Please upload the revised layout plan from the applicant onto Ocella for A/122/19/OUT.

We have just had a discussion in the office about the revised layout plan and we are happy for the **Locally Equipped Area of Play (LEAP)** to stay within the Central Green as shown on Drawing No. CSA/3467/136 Rev. C.

Figure 5.2: Illustrative Masterplan.

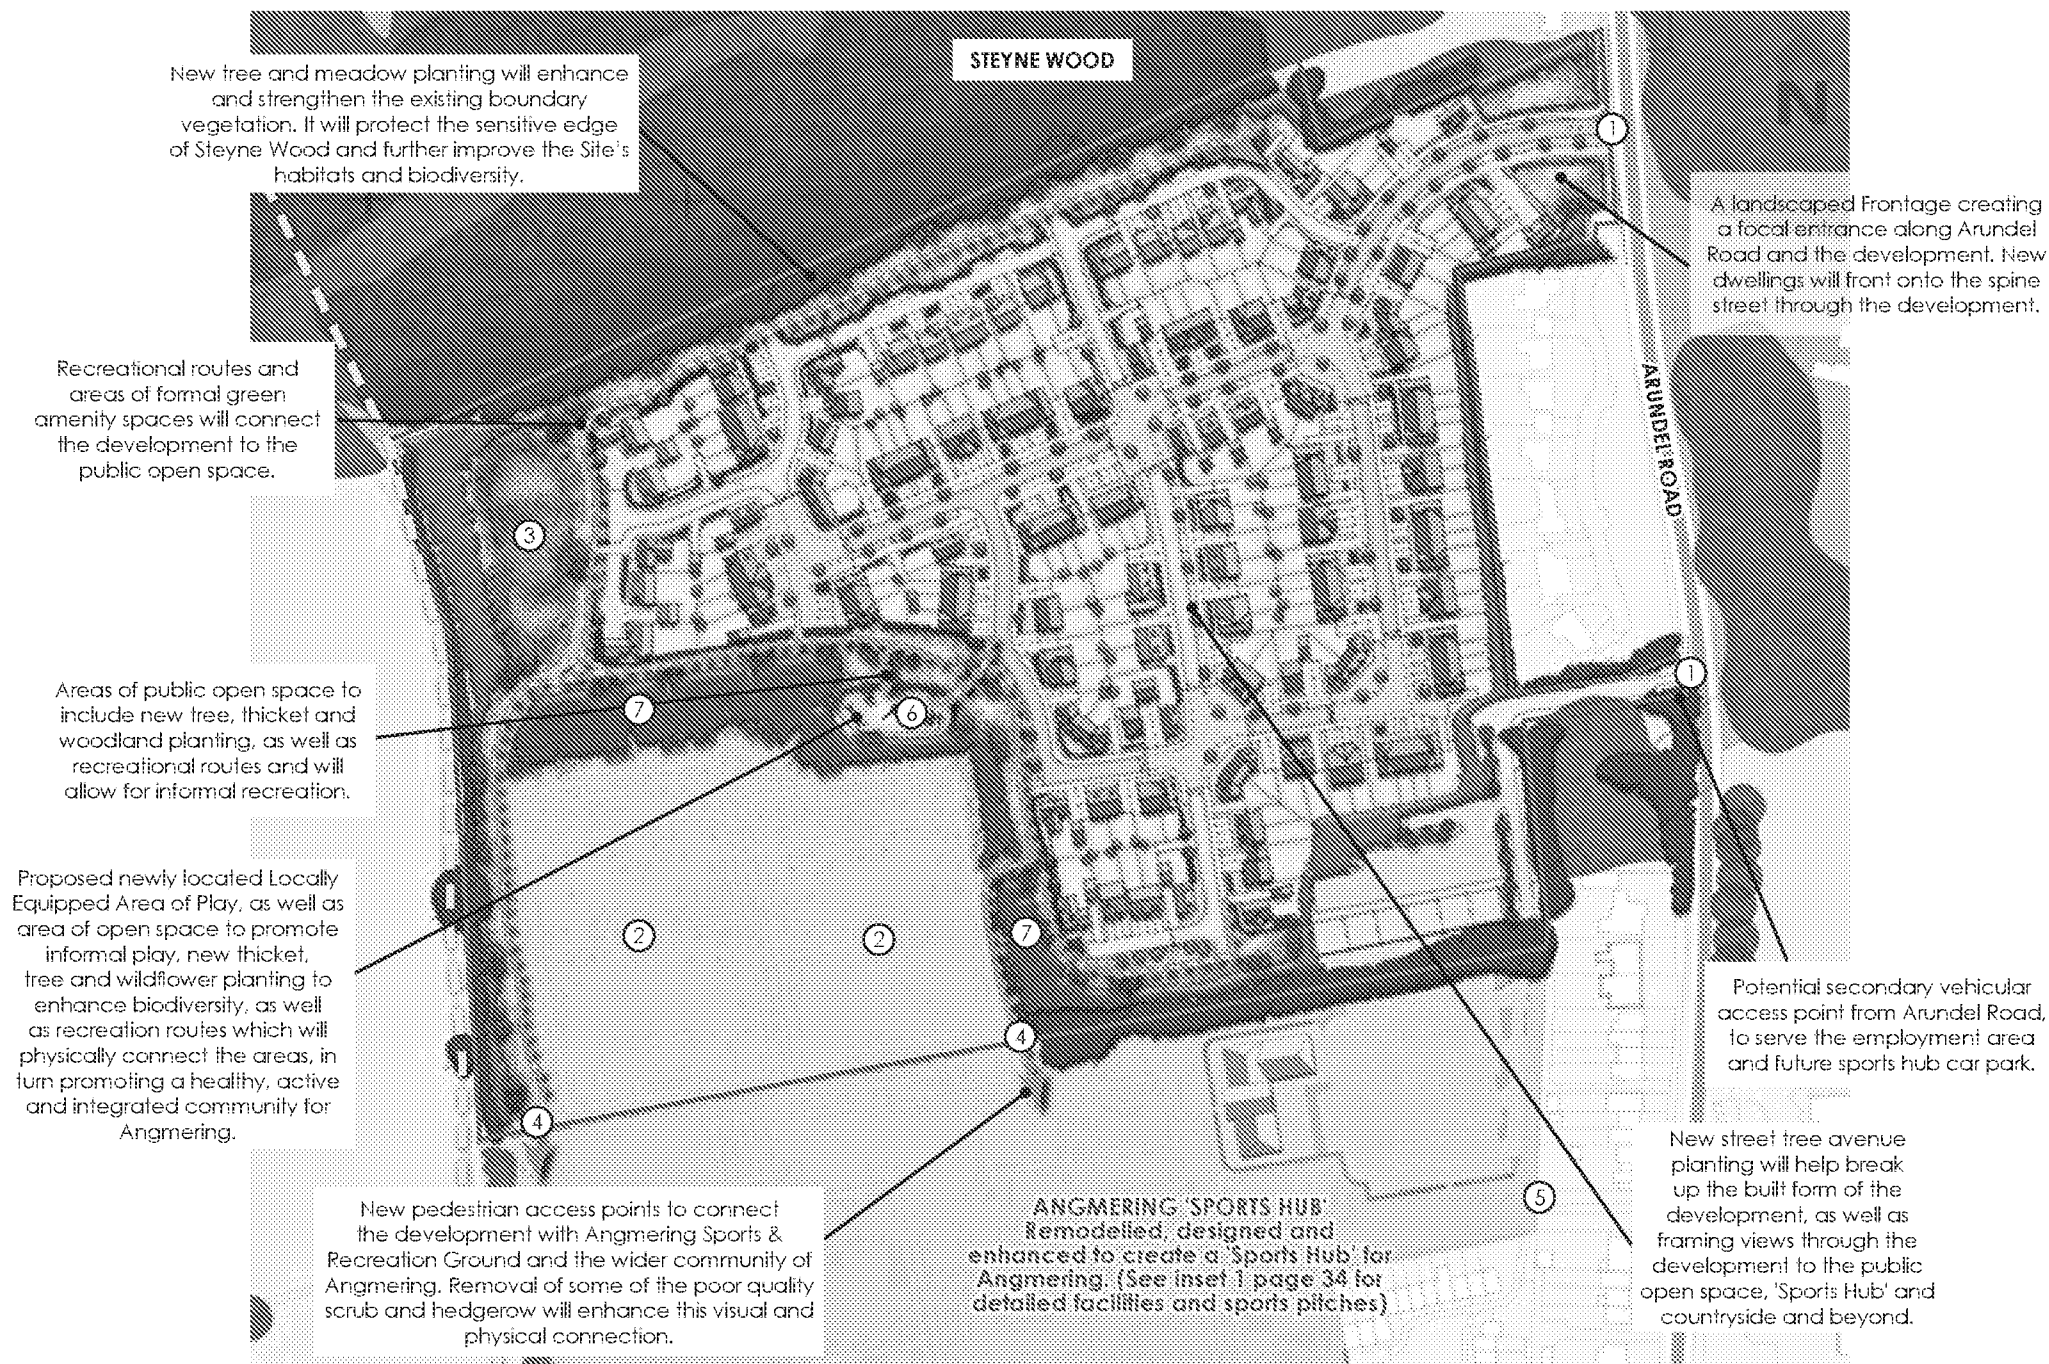
Please could a **Local Area of Play (LAP)** be added to the layout plan? It would be good if the LAP was located within the residential area.
